BOTLEY WEST SOLAR FARM
OXFORDSHIRE HOST AUTHORITIES
RESPONSES FOR
DEADLINE 7 | MONDAY 10 NOVEMBER 2025

Botley West Solar Farm (EN01014)

RESPONSES FOR DEADLINE 7

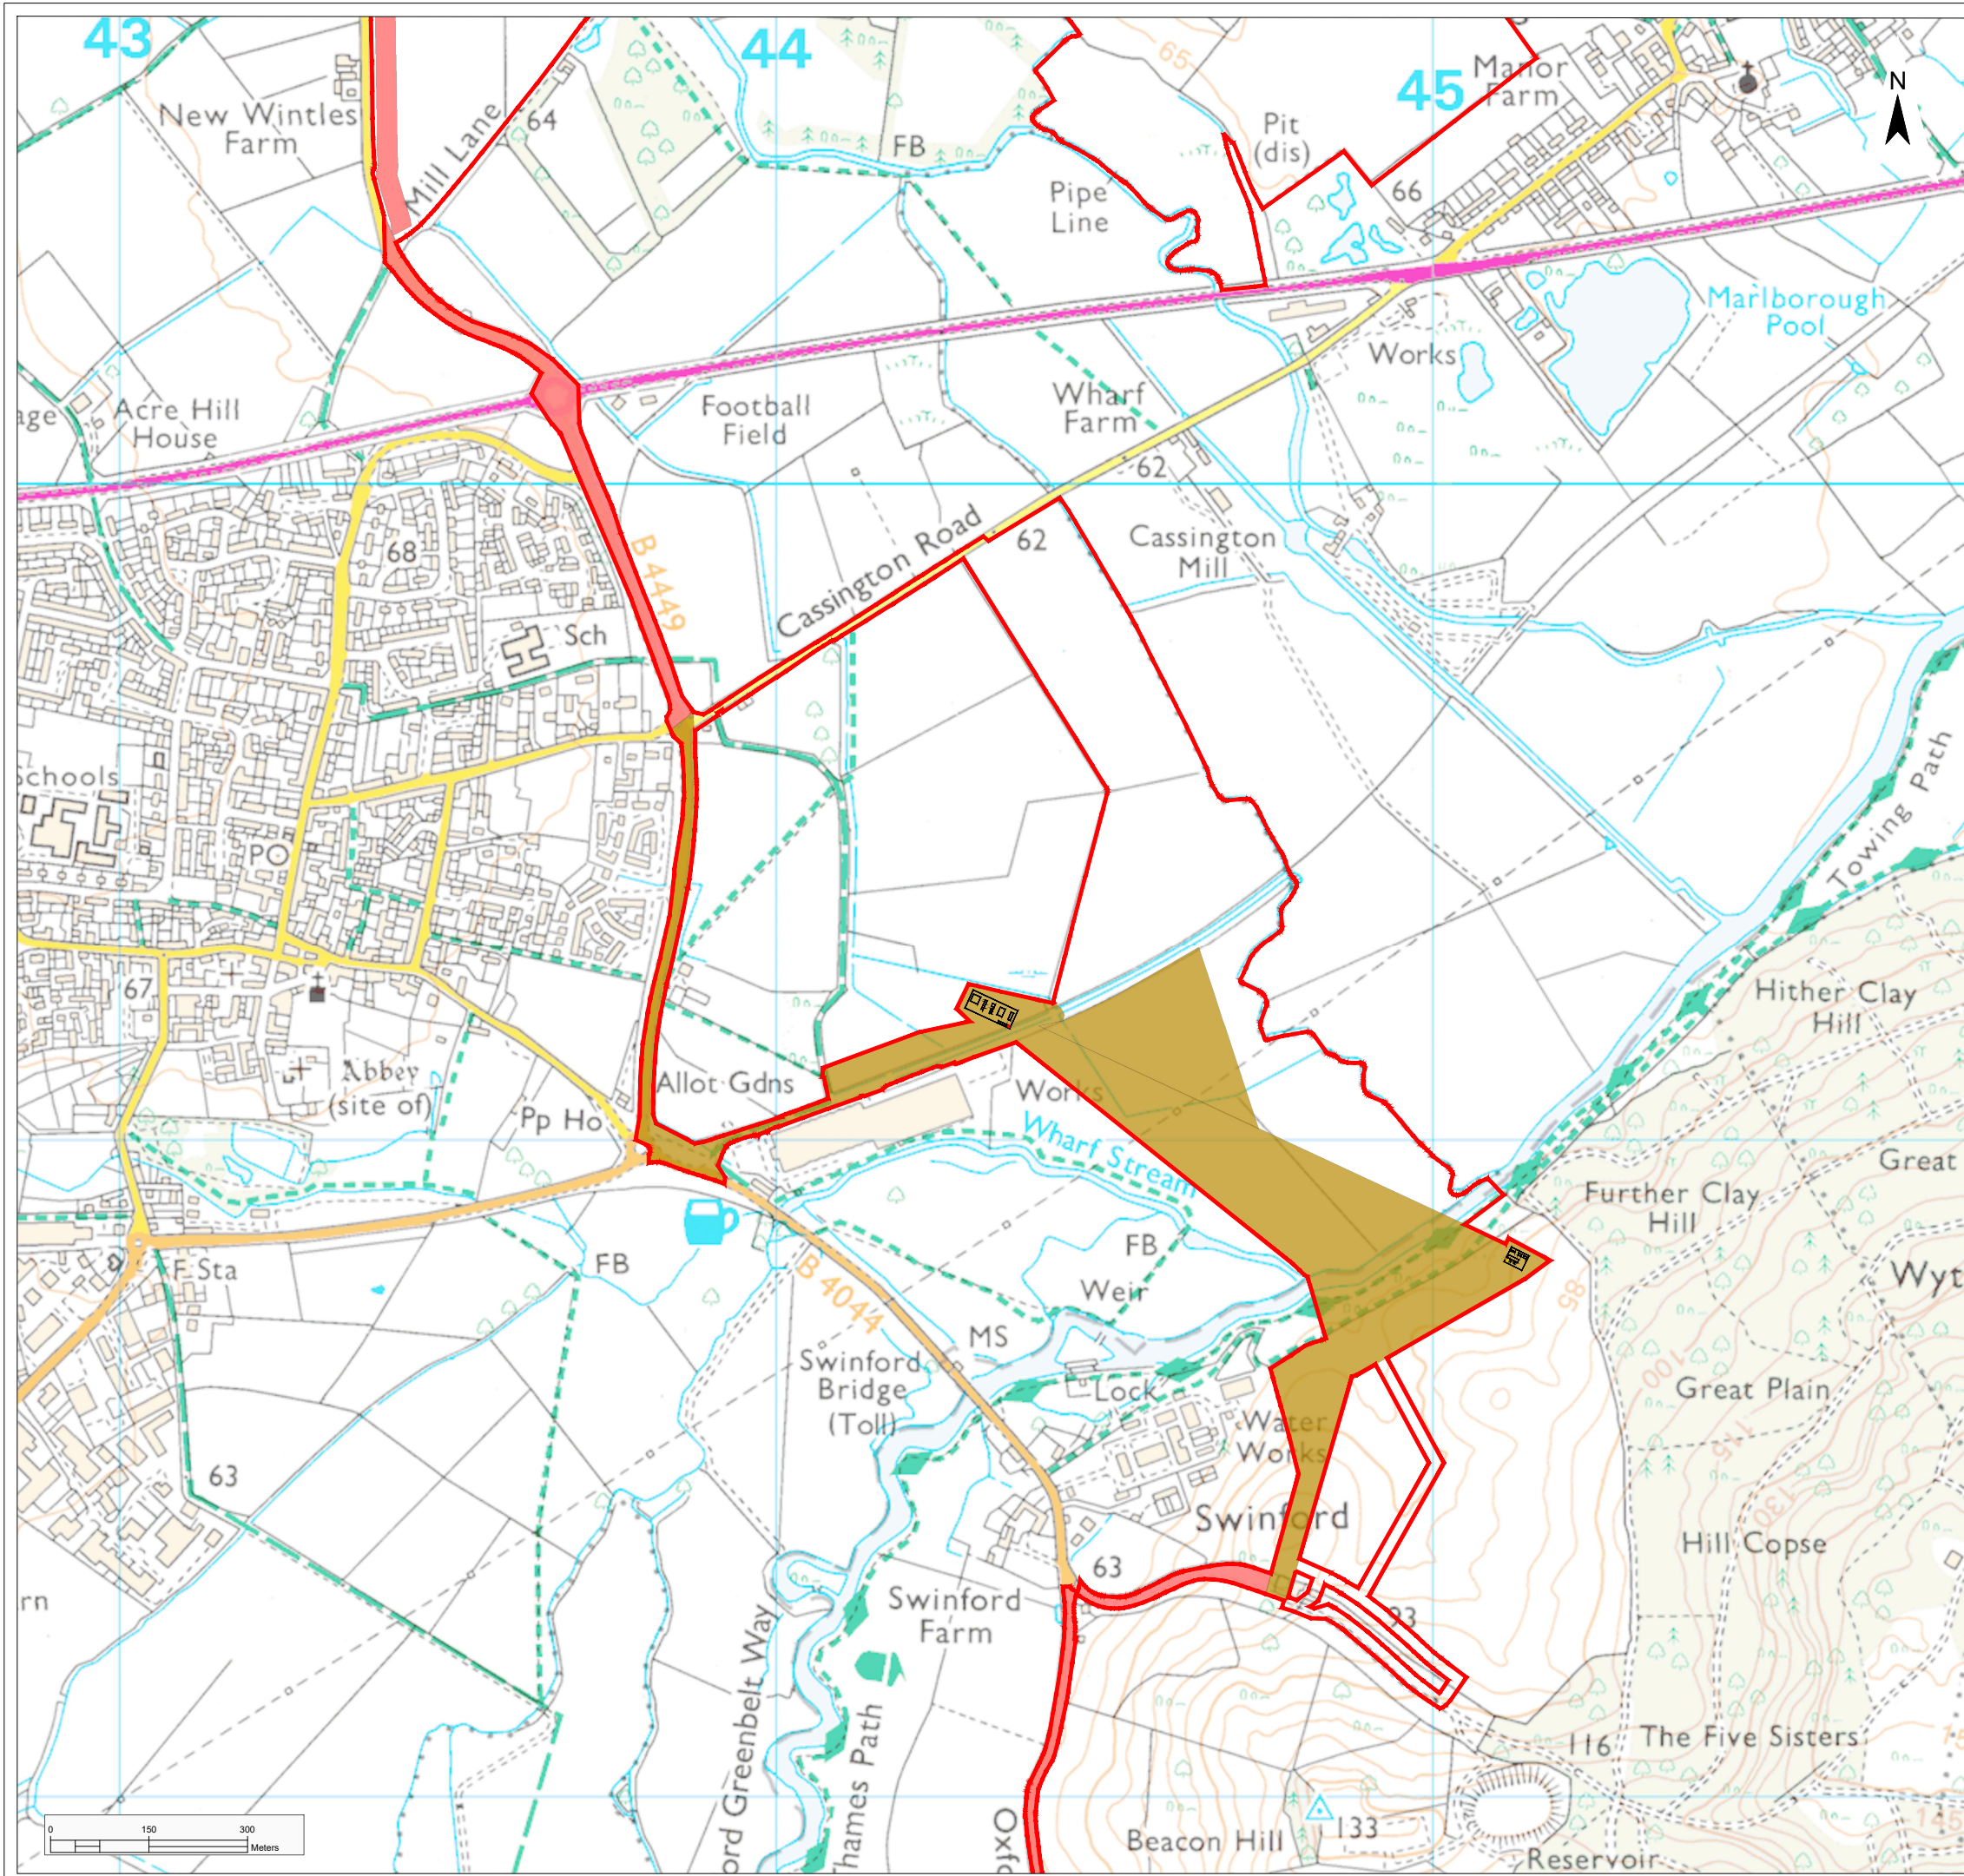
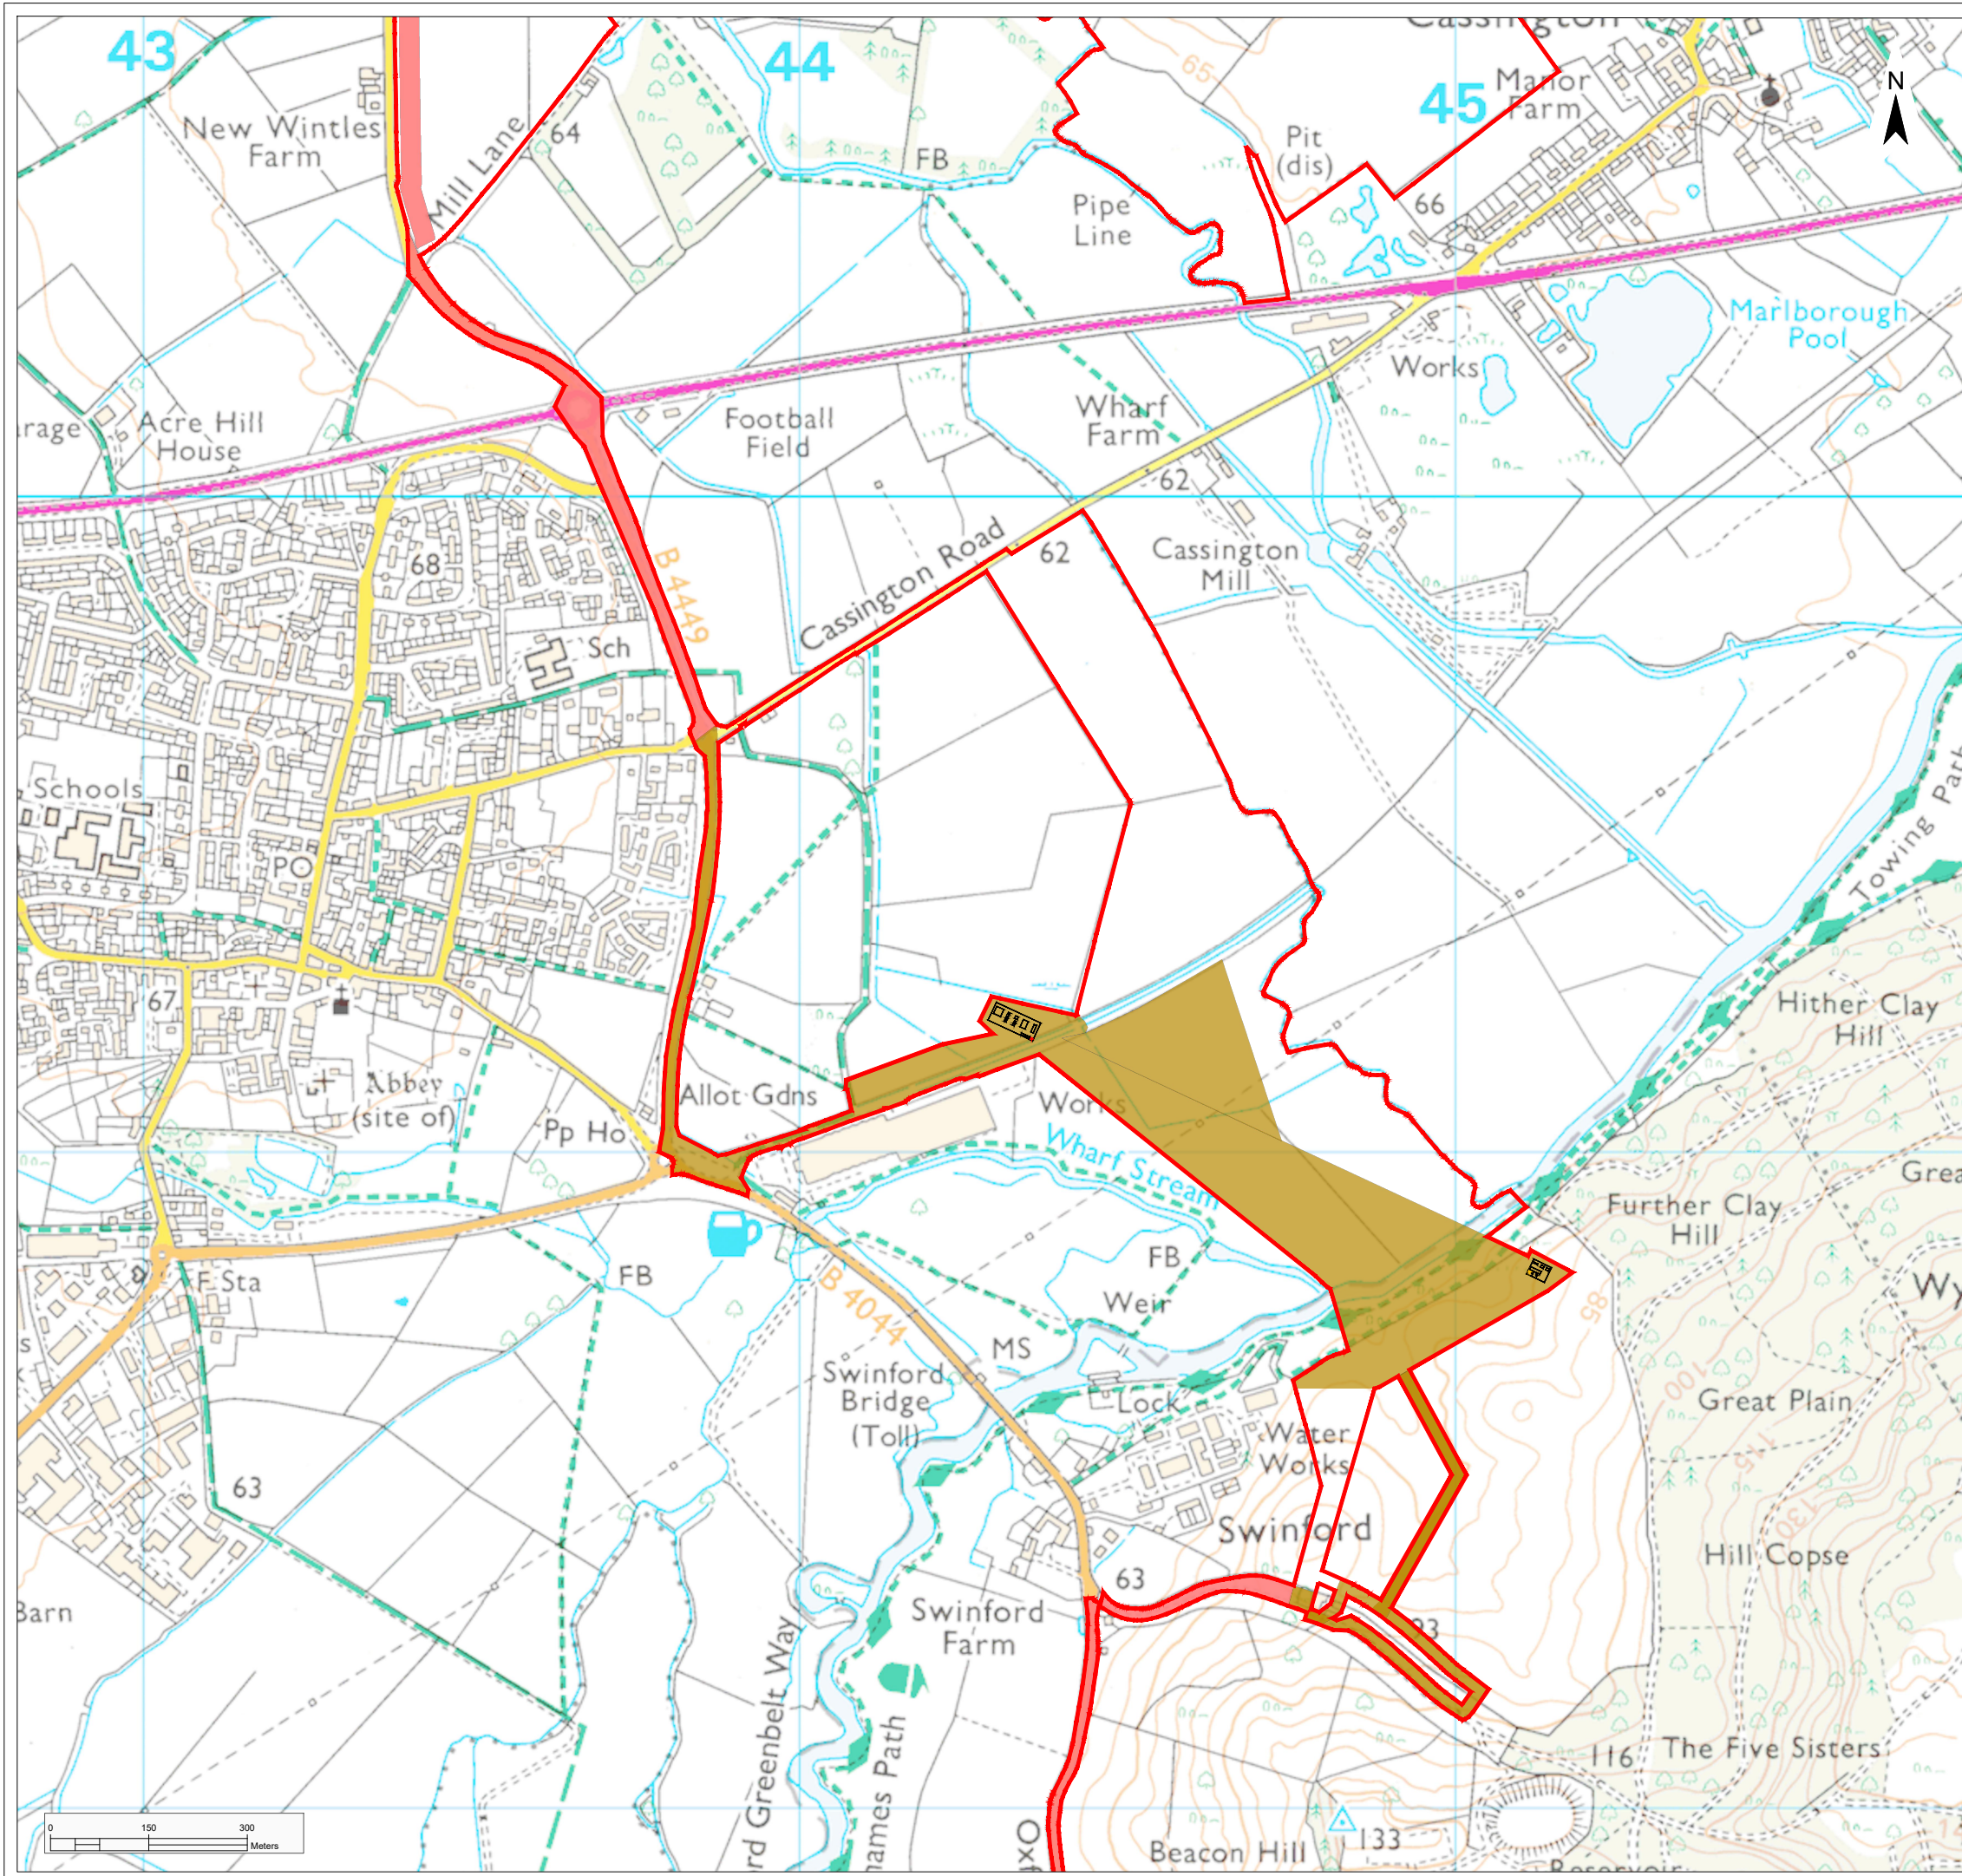
The panels within Field 2.20 have been removed for this field on the illustrative masterplan. If this field is to be part of the scheme however then a buffer area will need to be added to protect the features identified within the NE corner of this field as identified from the evaluation and geophysical survey.
